DRB CASE ACTION LOG (PREL & FINAL)

DRB Application No.: 04DRB-01325 (P&F)	Project # 1003371
Project Name: DRIVE TIME @ ALAMEDA	
Agent: Mark Goodwin & Associates	Phone No.: 828-2200

Project Name: DRIVE TIME @ ALAMEDA

PLAT FOR
LOT 31-A, BLOCK 11
TRACT A, UNIT B
NORTH ALBUQUERQUE ACRES
 WITHIN THE
 ELENA GALLEGOS GRANT
 PROJECTED SECTION 13
 TOWNSHIP 11 NORTH, RANGE 3 EAST, NMMP
 CITY OF ALBUQUERQUE
 BERNALILLO COUNTY, NEW MEXICO
 JULY, 2004

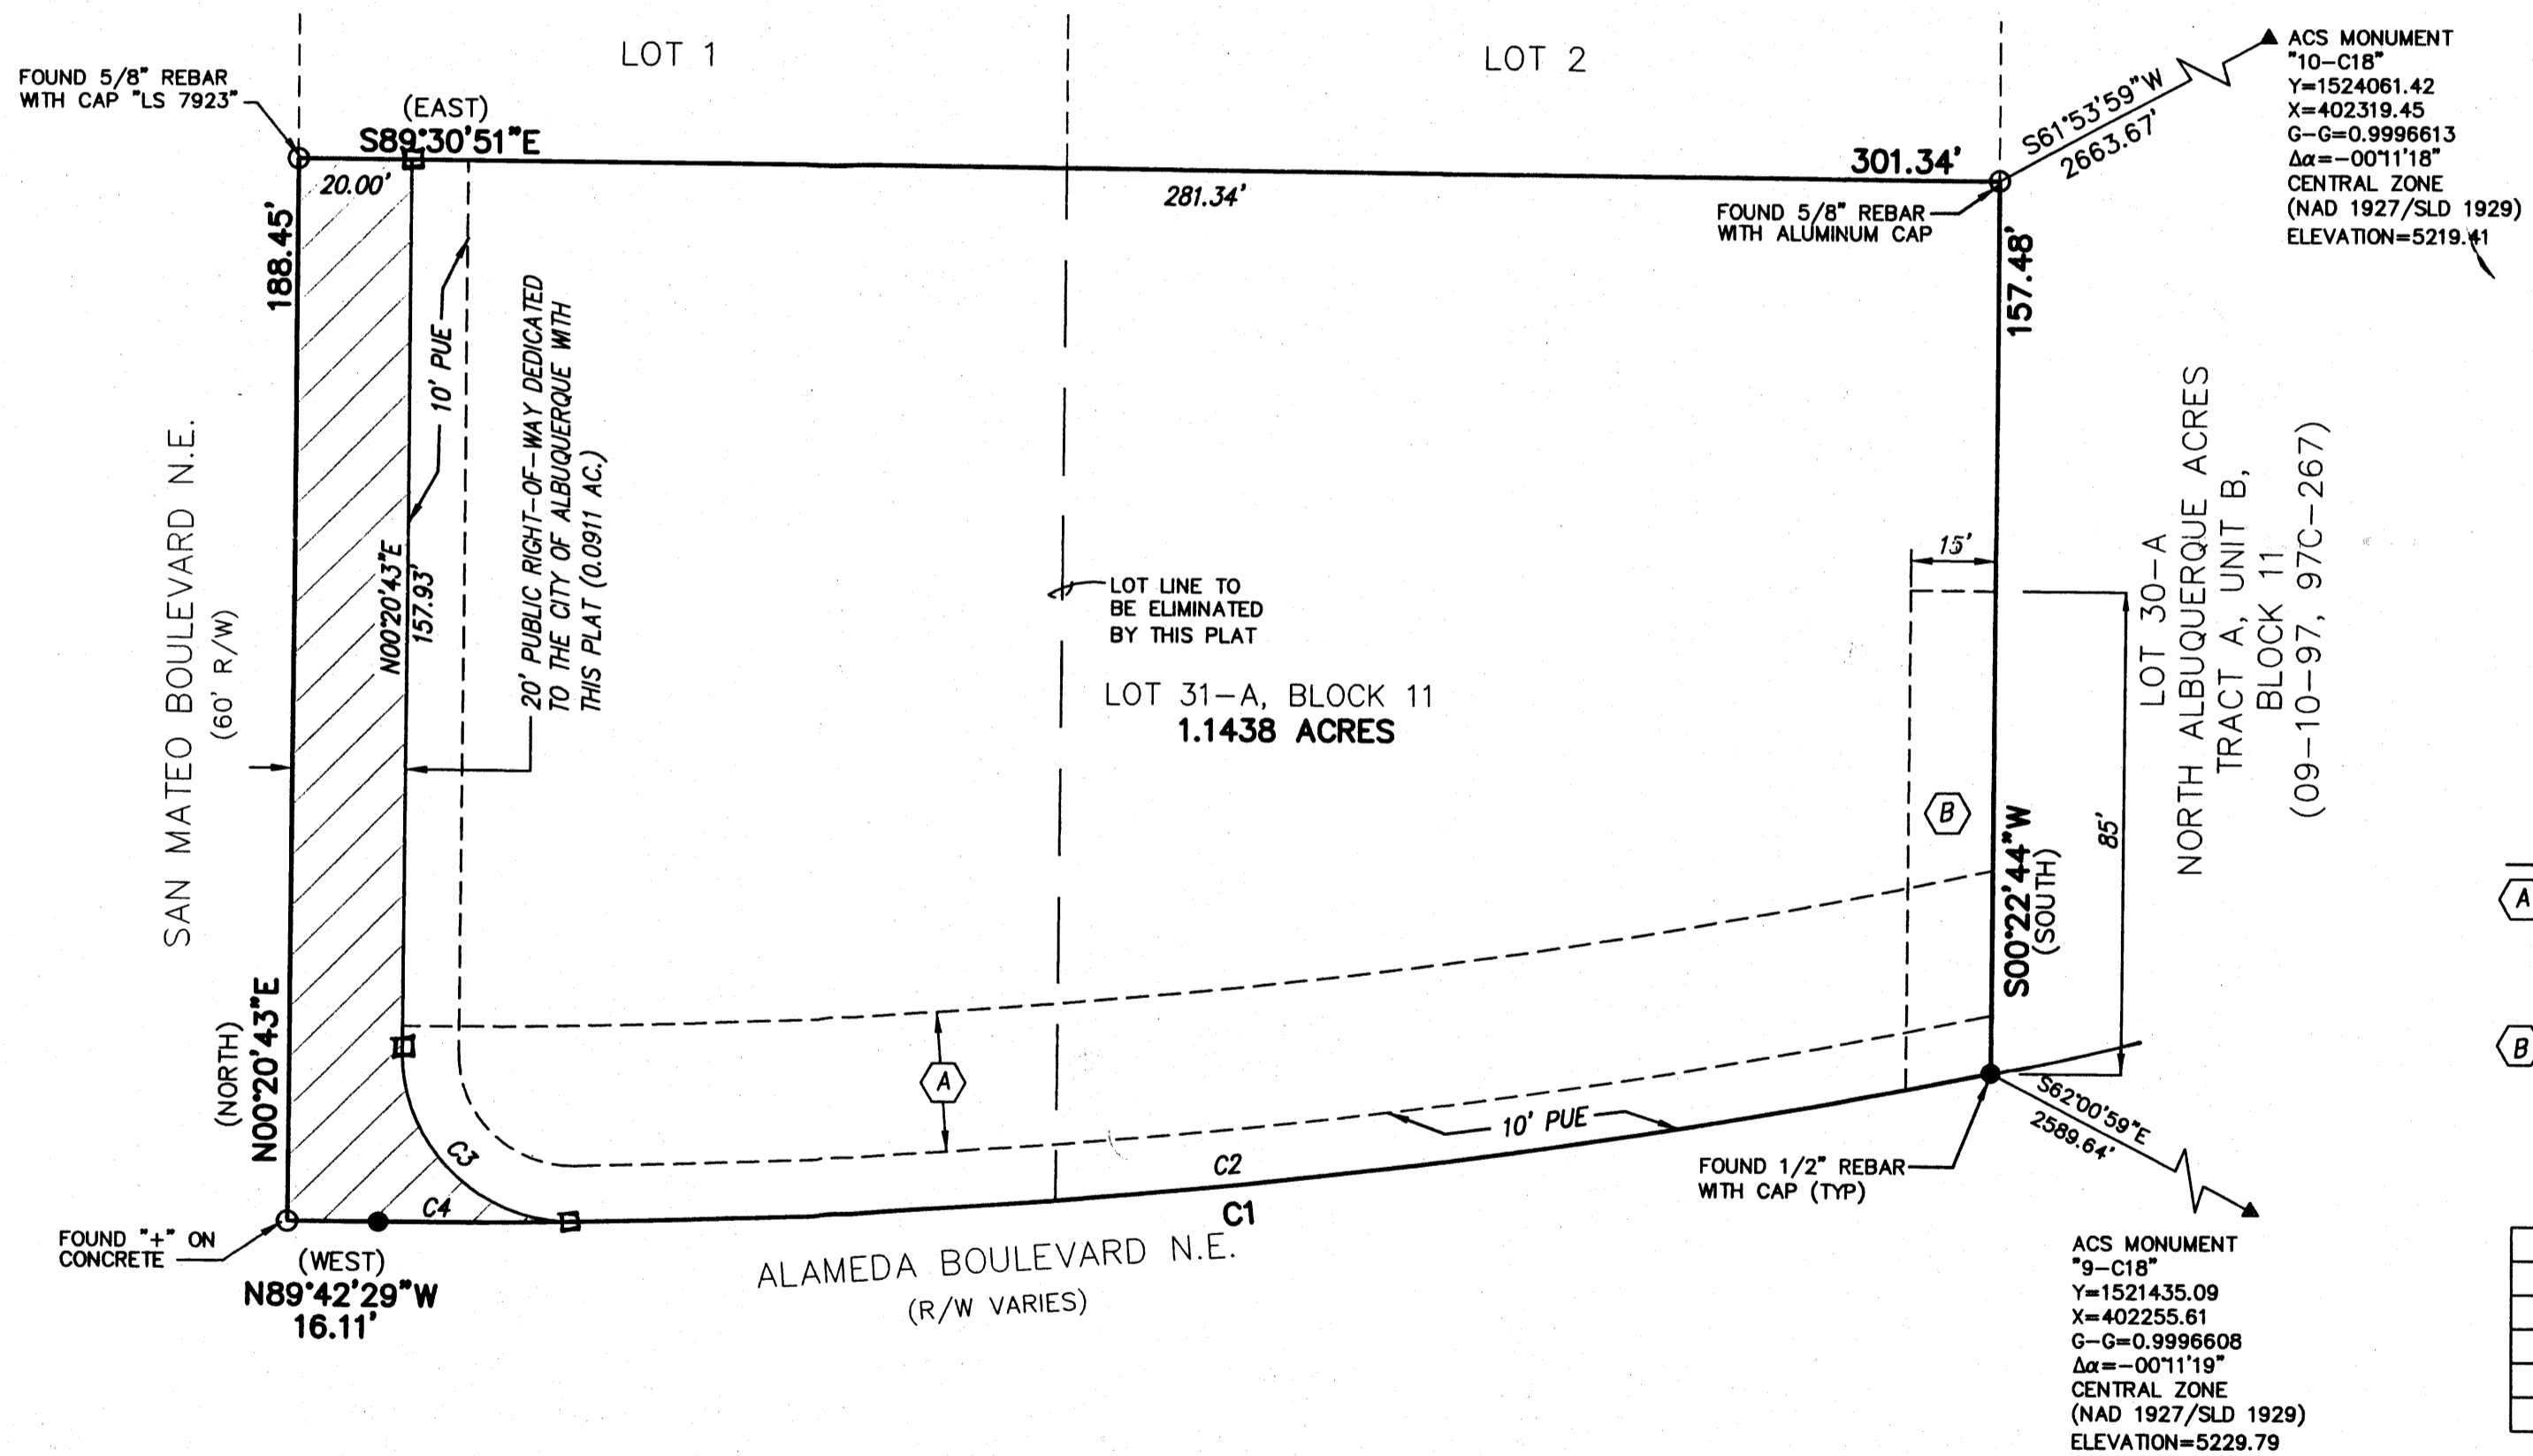
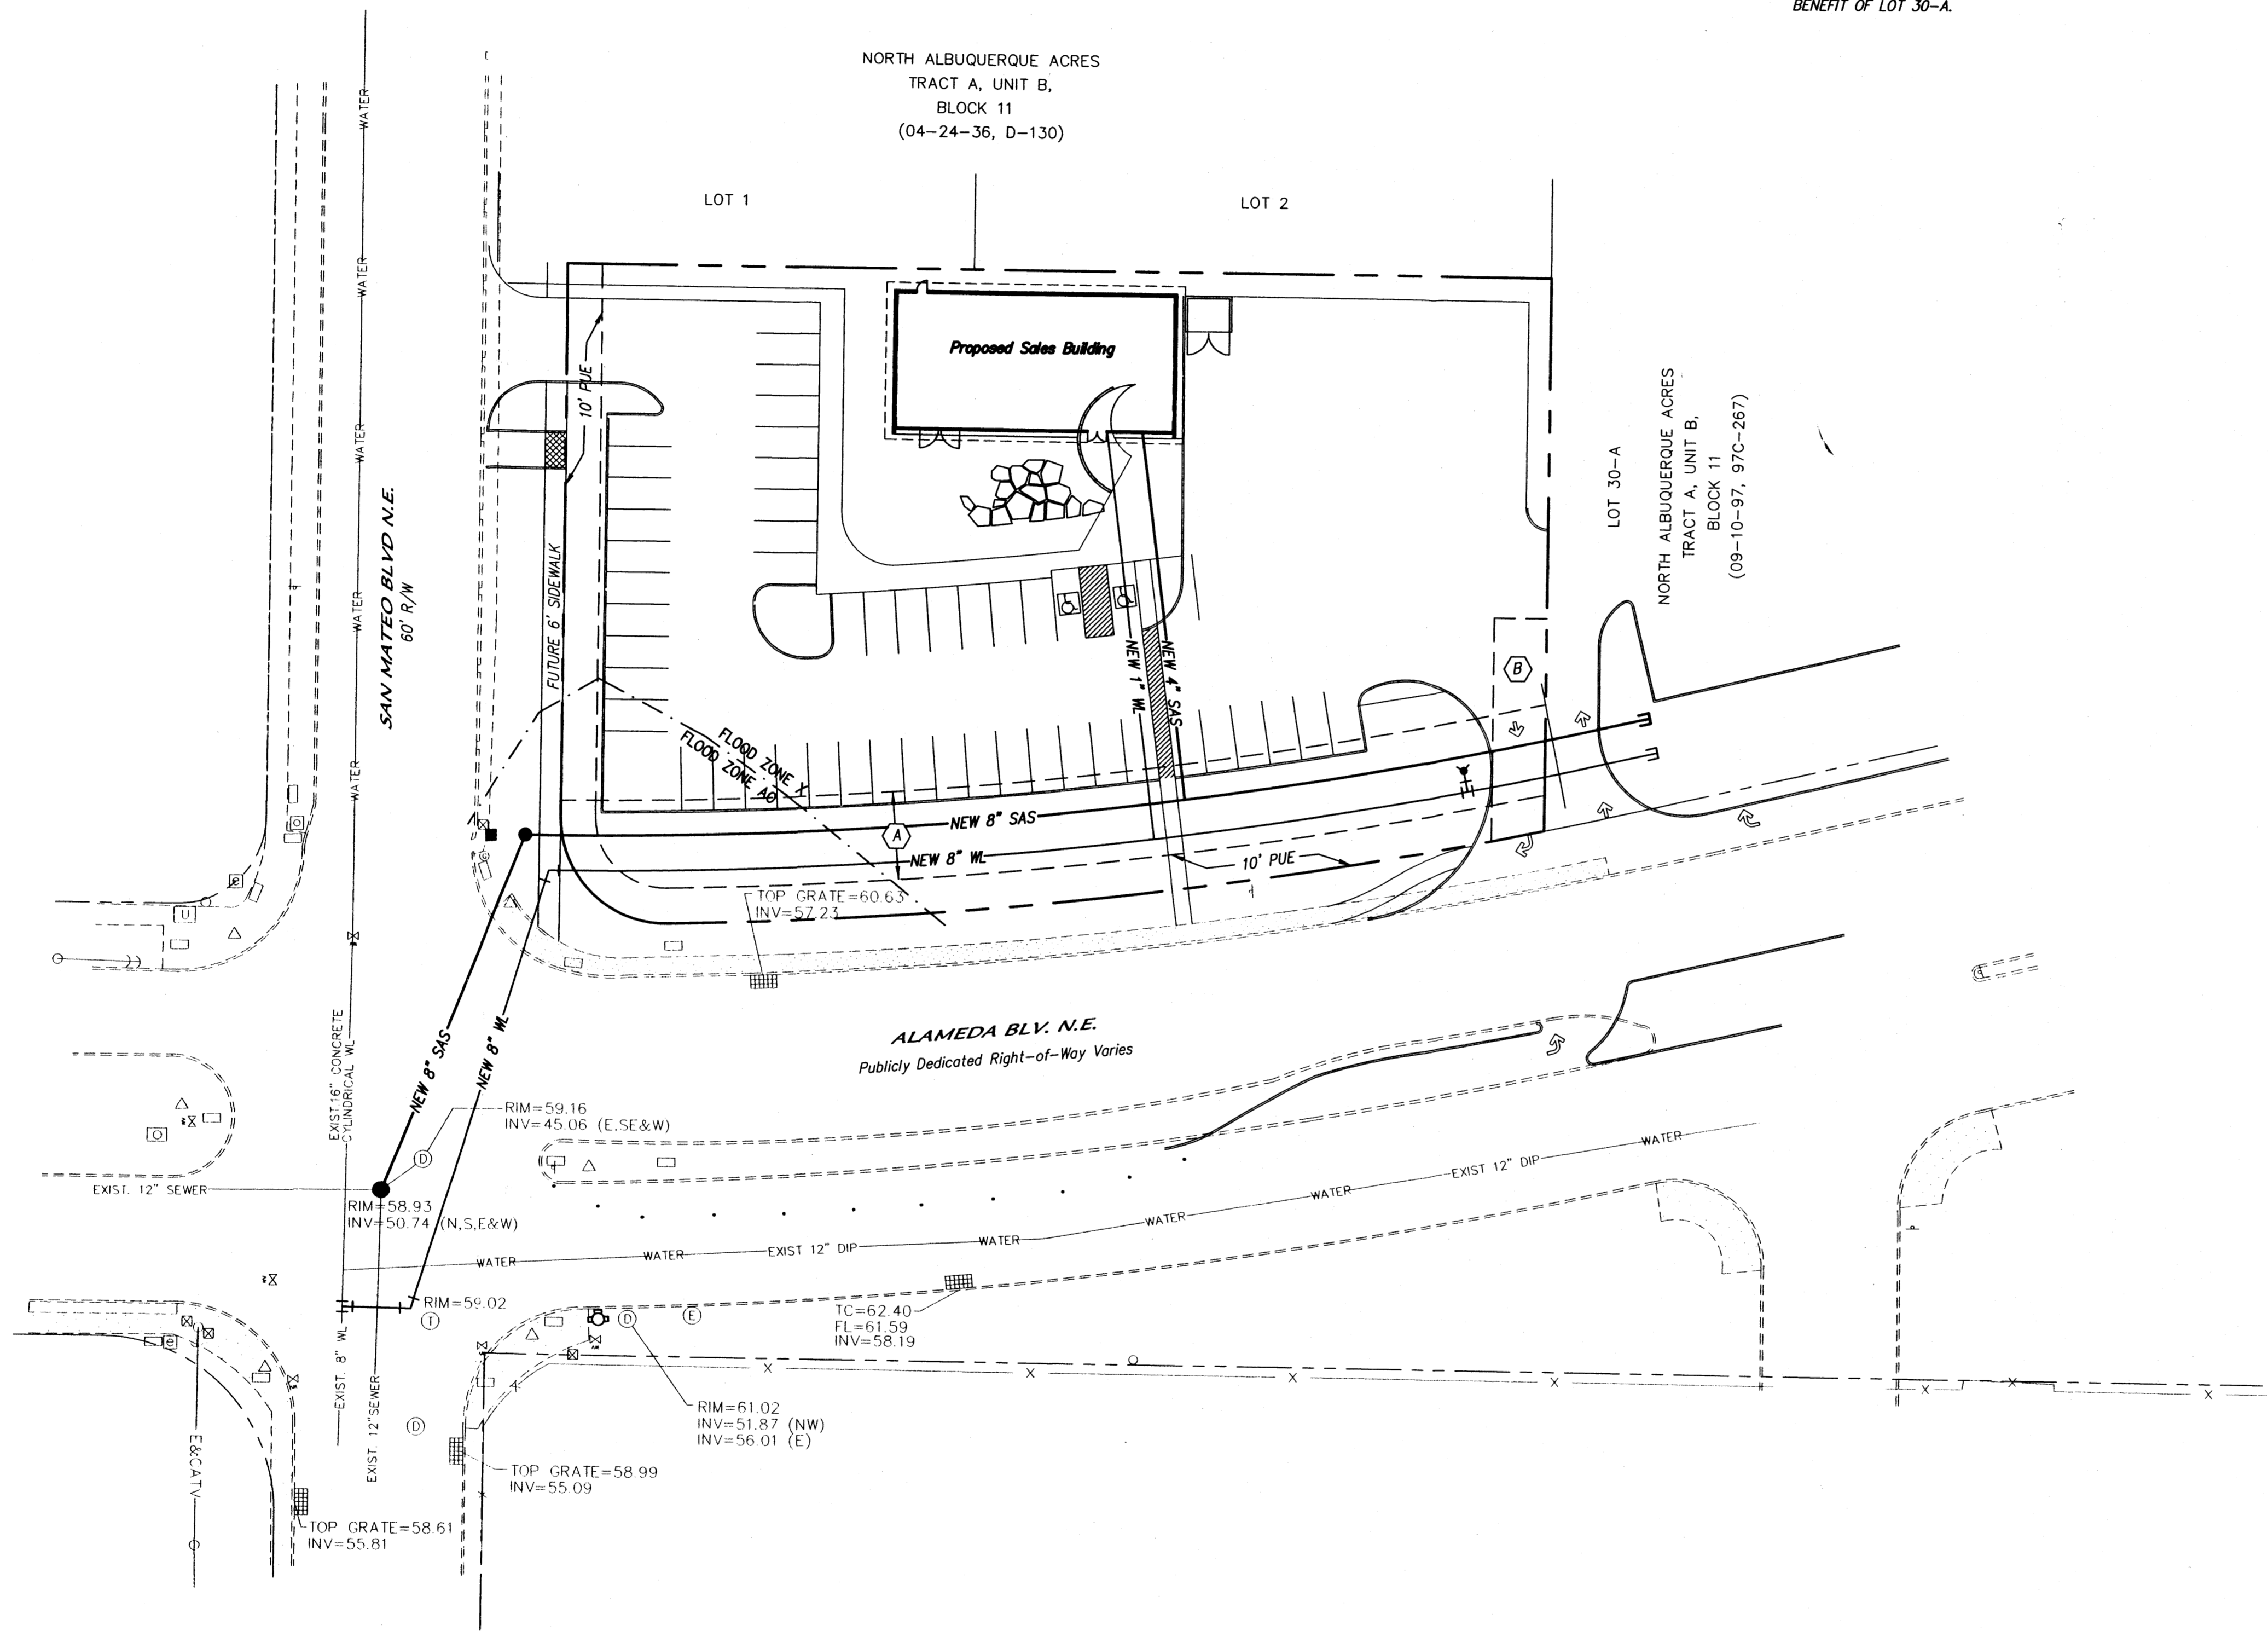
UTILITIES: Need a 20-ft. wide public water easement from proposed (A) easement to Alameda ROW
AGIS DXF
Signed [Signature] 1/17/04
